**KIRKLEES METROPOLITAN COUNCIL
INVESTMENT & REGENERATION SERVICE**

DELEGATED DECISION TO DETERMINE PLANNING APPLICATIONS

Reference No: 2018/62/94088/W
Site Address: 2, New Street, Golcar, Huddersfield, HD7 4DZ
Description: Erection of single storey side extension (within a Conservation Area)
Recommending Officer: Callum Harrison

Drawing Title: Existing and Proposed Plans and Elevations and Site Location Plan

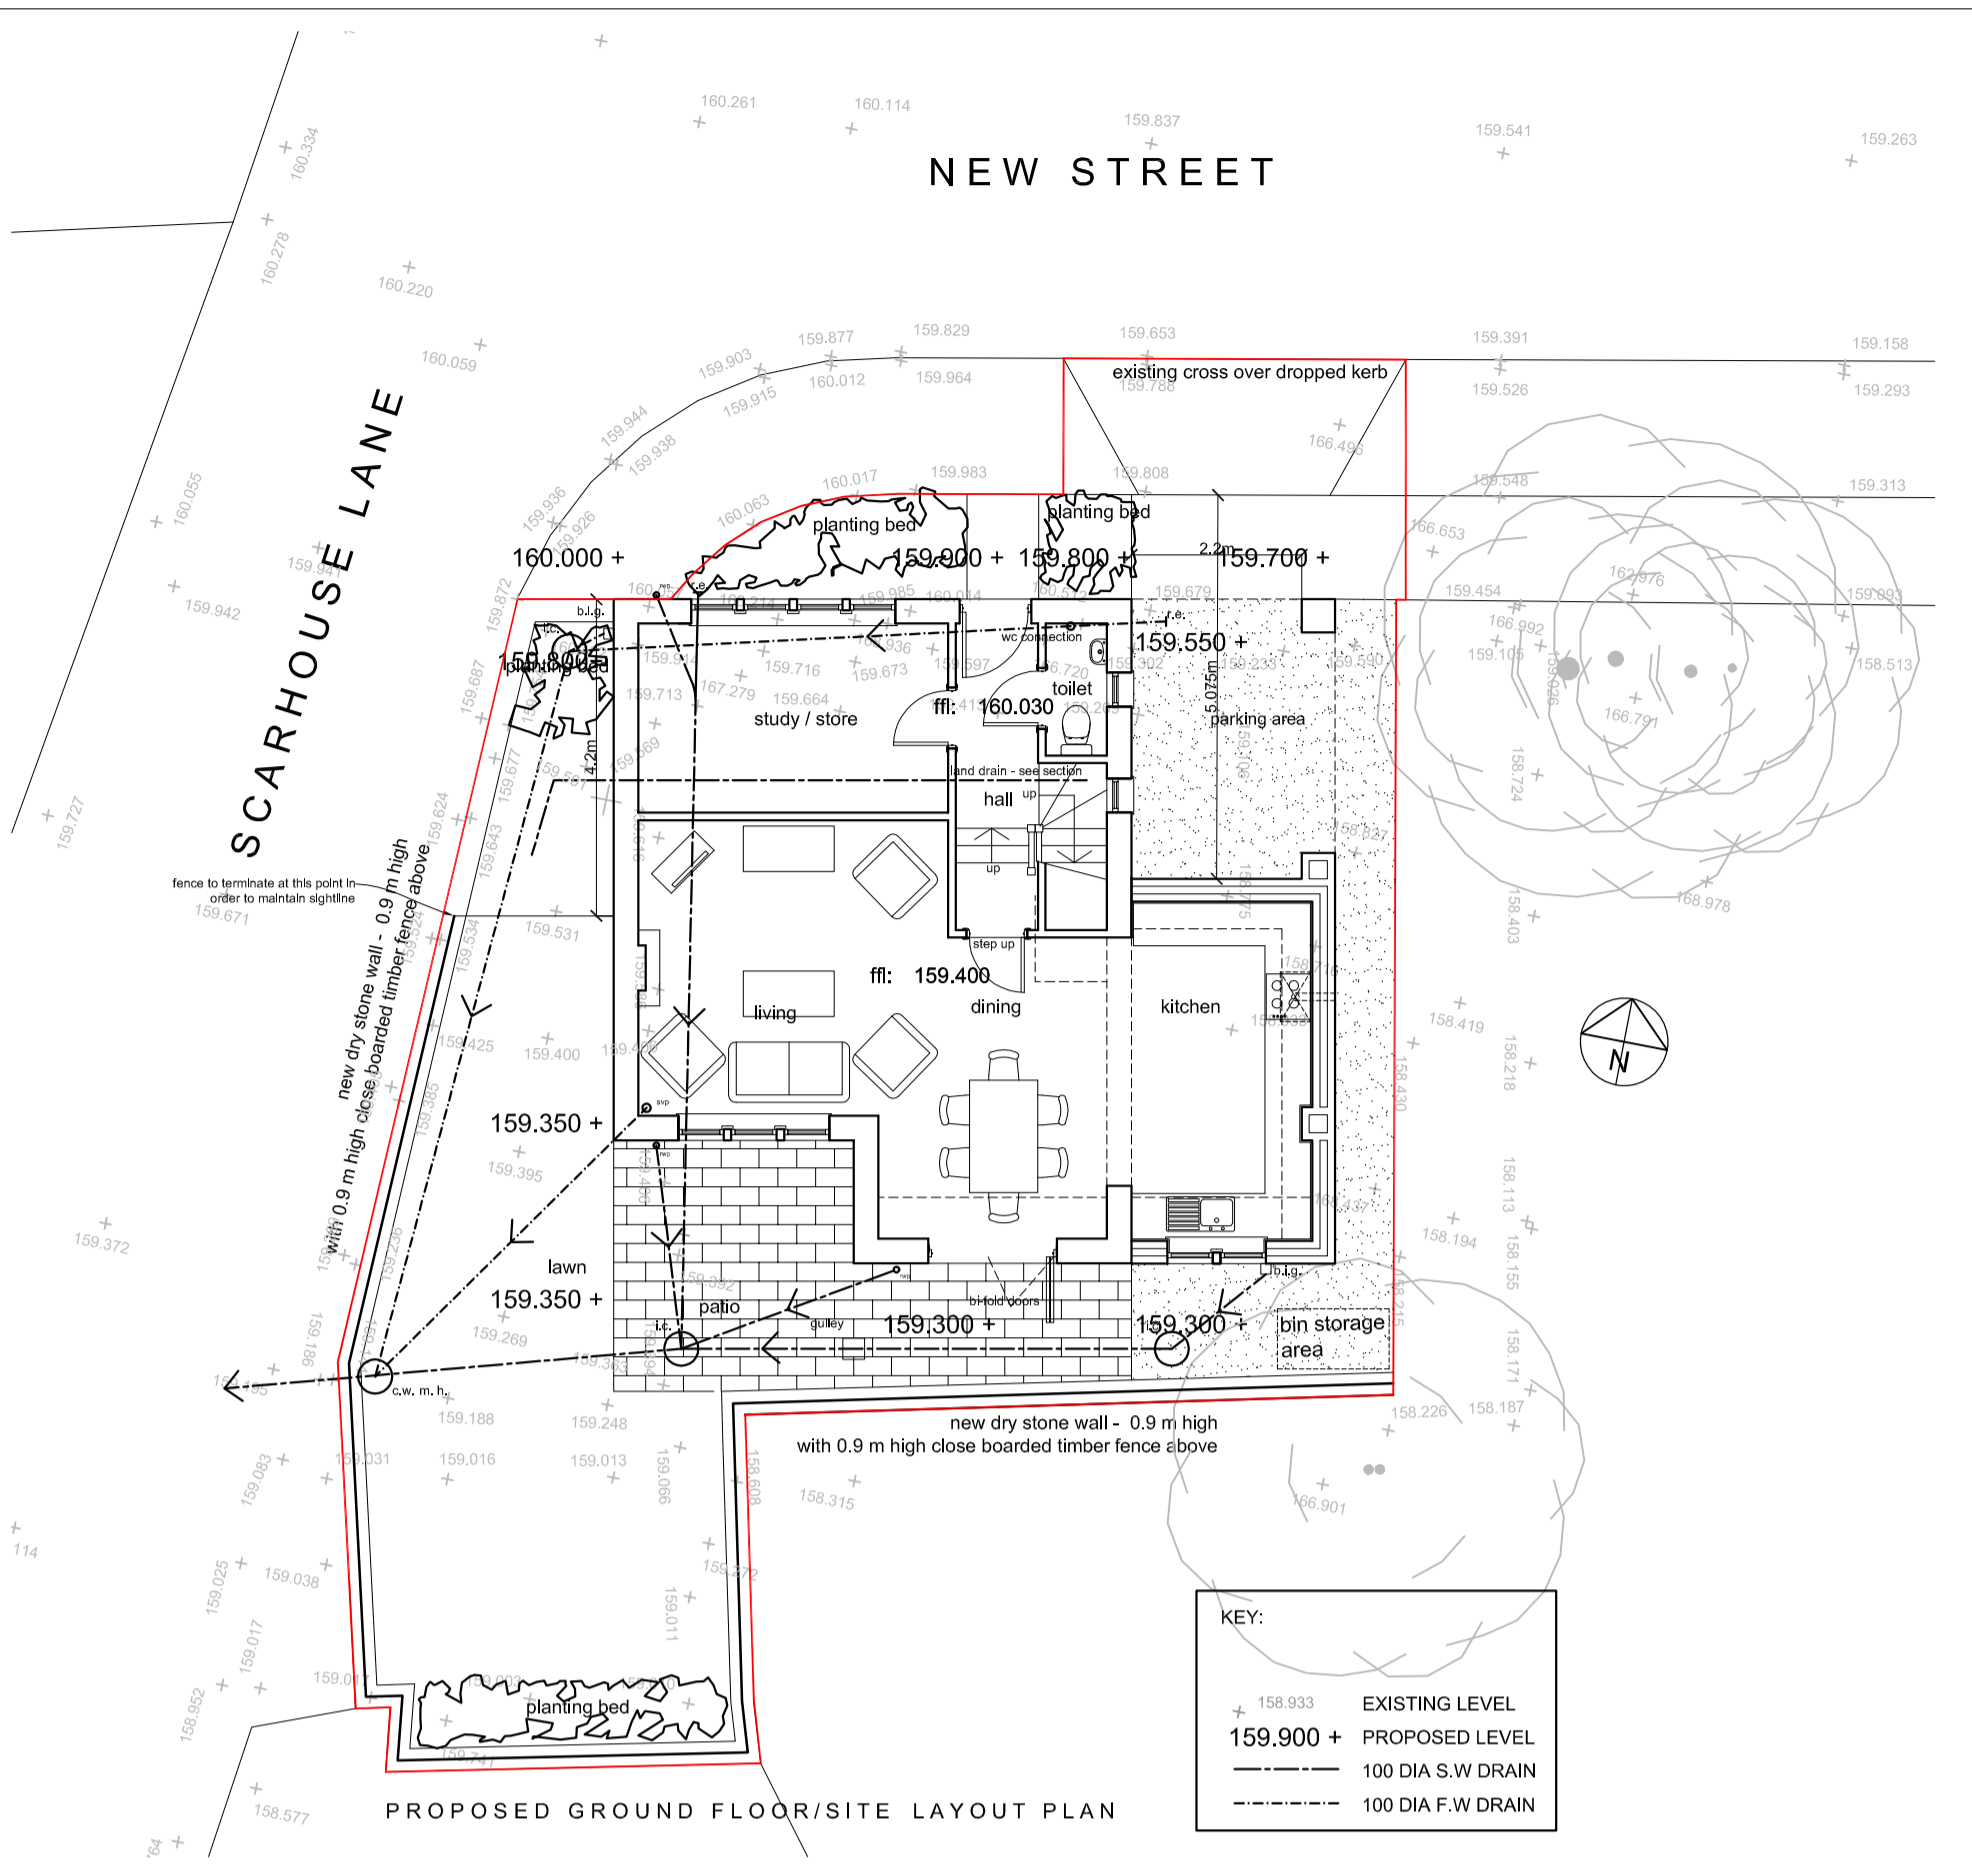
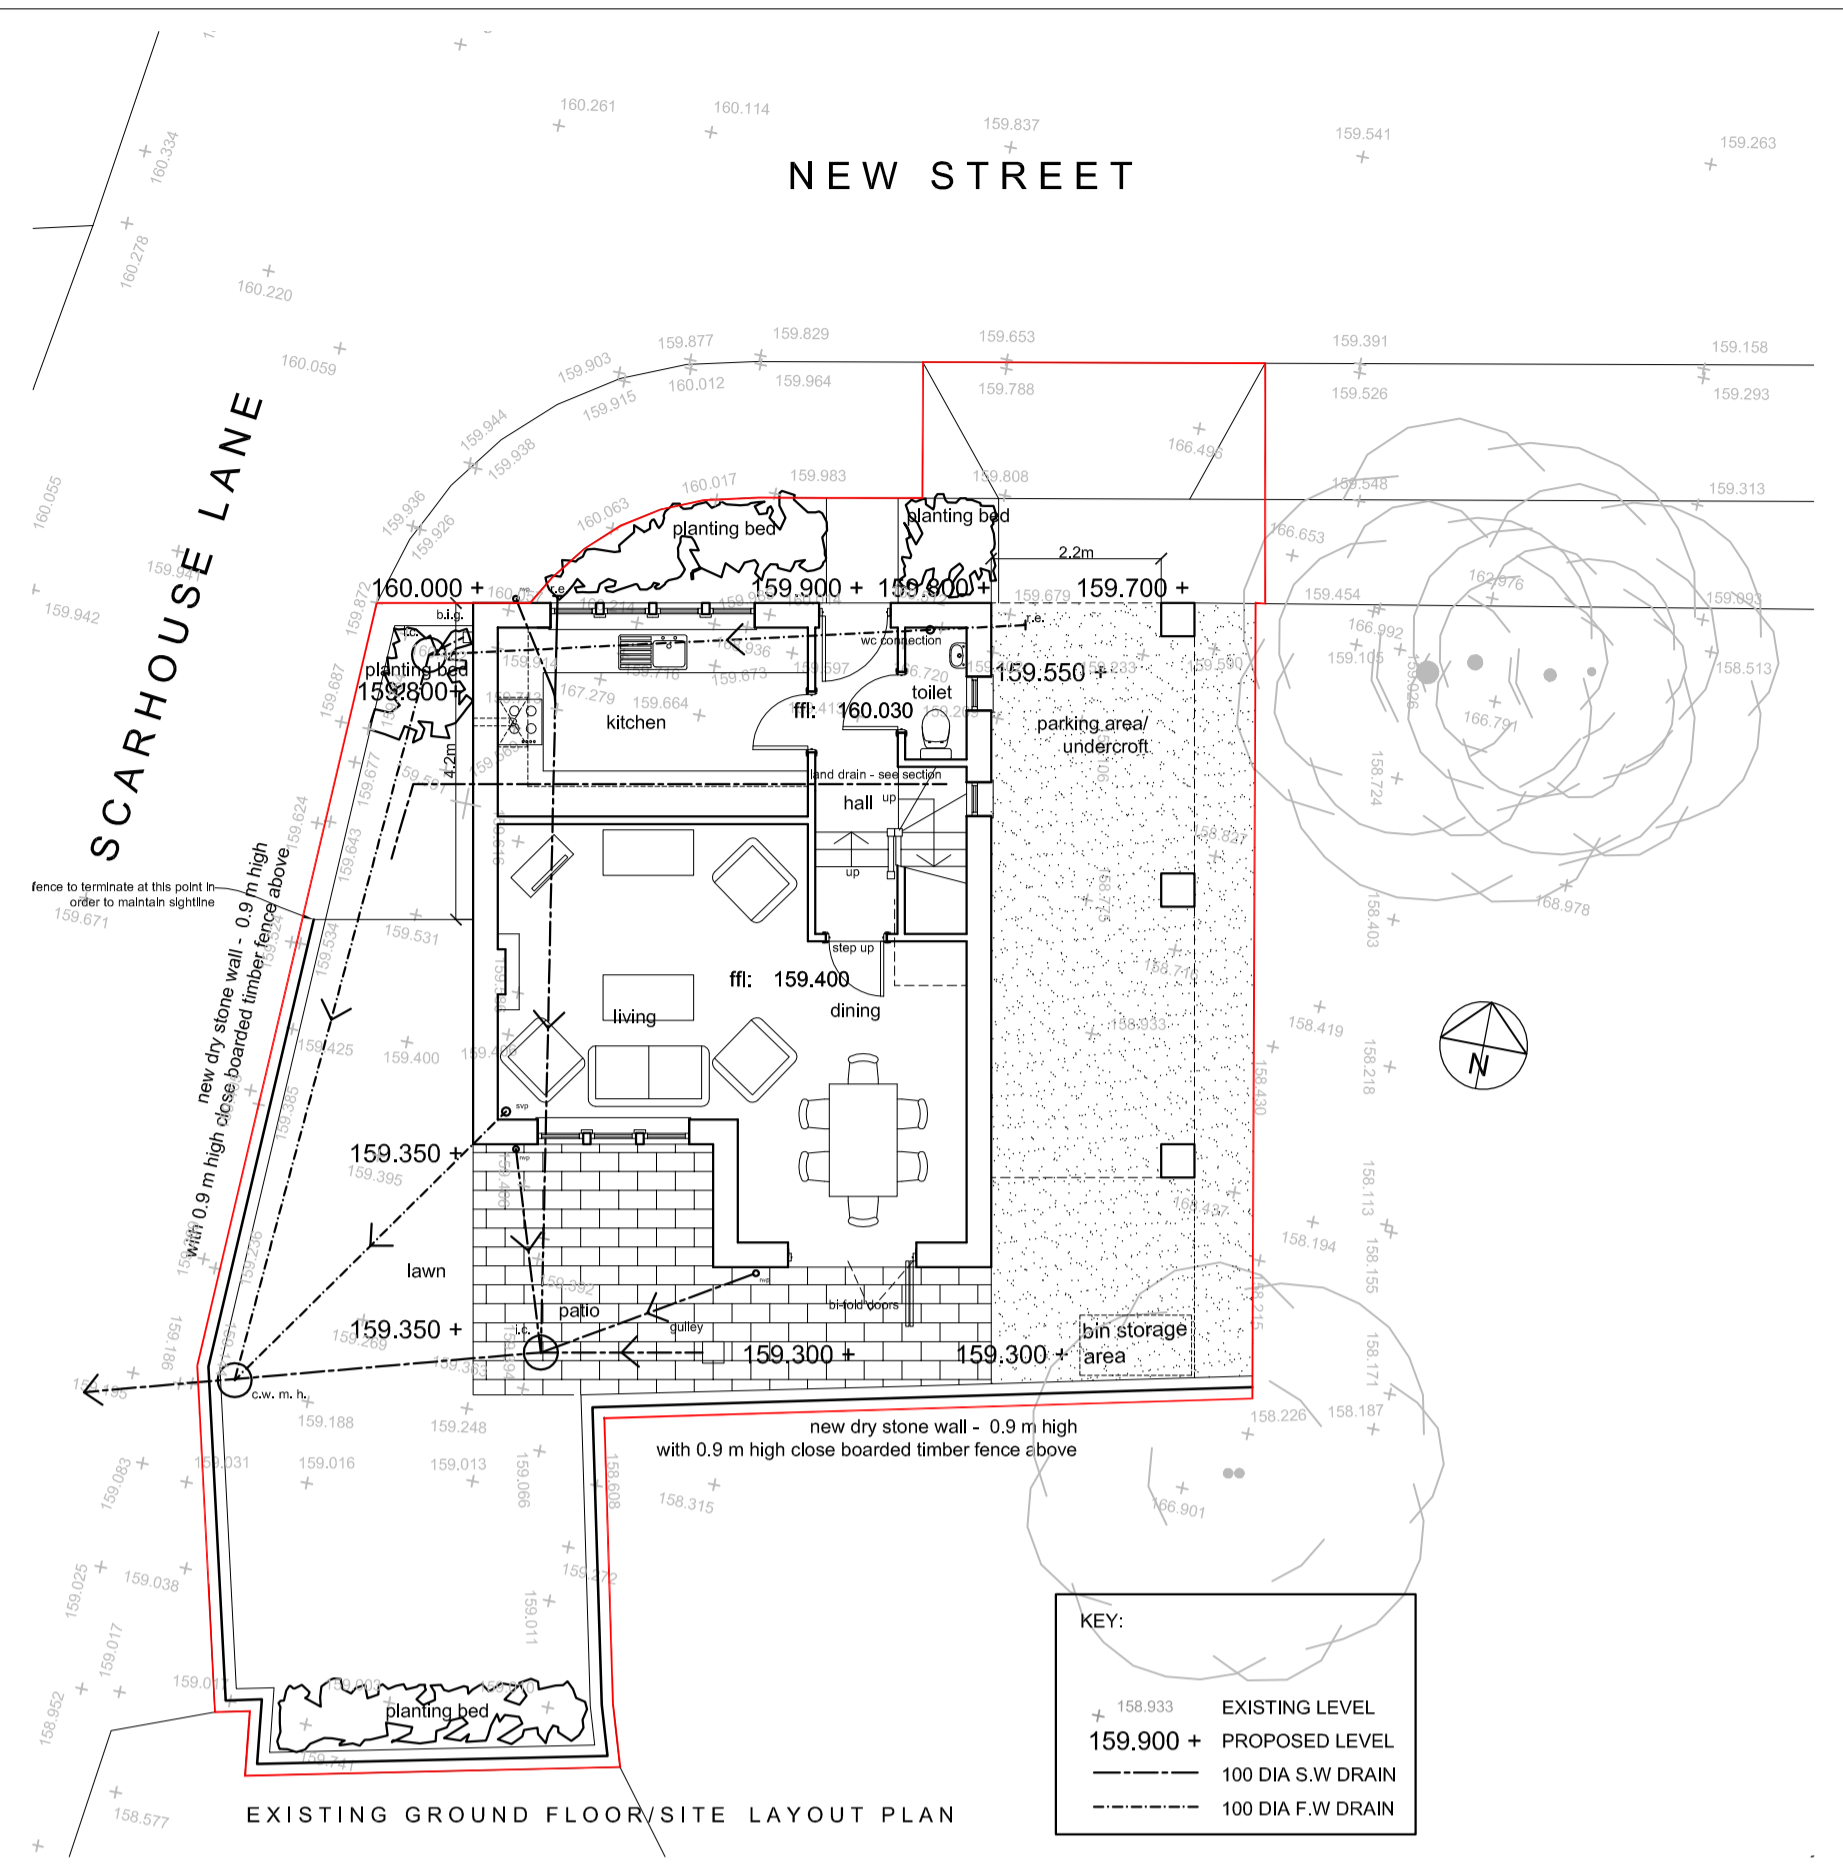
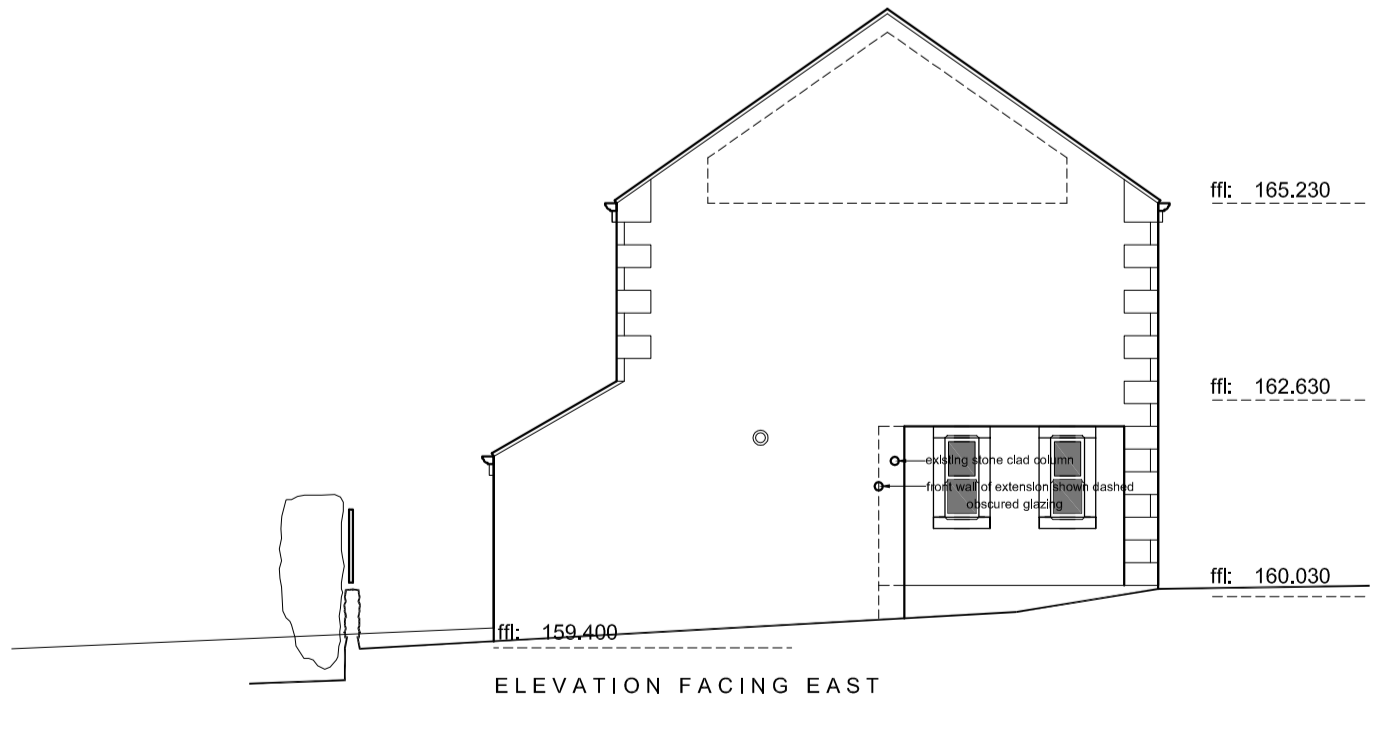
The application initially proposed the formation of a dropped kerb and driveway to the east side of the existing pillars. However this would have extended in to land which is within a TPO open area outside of the domestic curtilage. The agent was informed that a change of use application would be

The agent was also to show accessible bin storage which would not impact on parking provisions. This was shown on amended plans which saw bins to the rear of the extension and accessed via an existing 0.75m gap between the pillars and the boundary fence. This amendment was deemed acceptable.

The agent was also informed that the provision of 1 parking space with a minimum length of 5m was required. This was amended and shown on plans received 25/04/19.

required for this and that it was unlikely that a change of use application would be submitted due to the TPO designation and therefore the agent decided to remove the driveway from the proposal.
